APPLICATION REFERENCE H11/0956/02

NEW ILLUMINATED FASCIA, PROJECTING SIGN AND OTHER SIGNS

NATWEST BANK, 25 MARKET PLACE, LONG SUTTON

Illuminated fascia replaced with illuminated letters & logo

Proposed Components

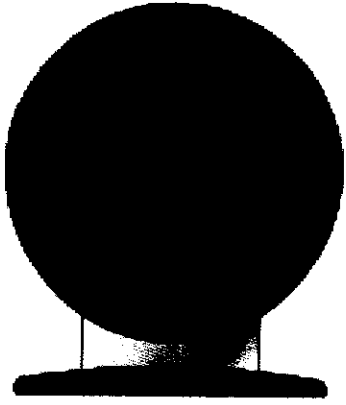
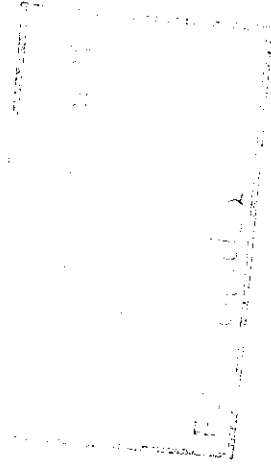
After consideration of your views, it is now proposed that the illuminated fascia that formed part of the original submission be replaced by individual illuminated 'NatWest' letters and logo. Please find enclosed 4 no. copies of an amended photo montage illustrating this revision.
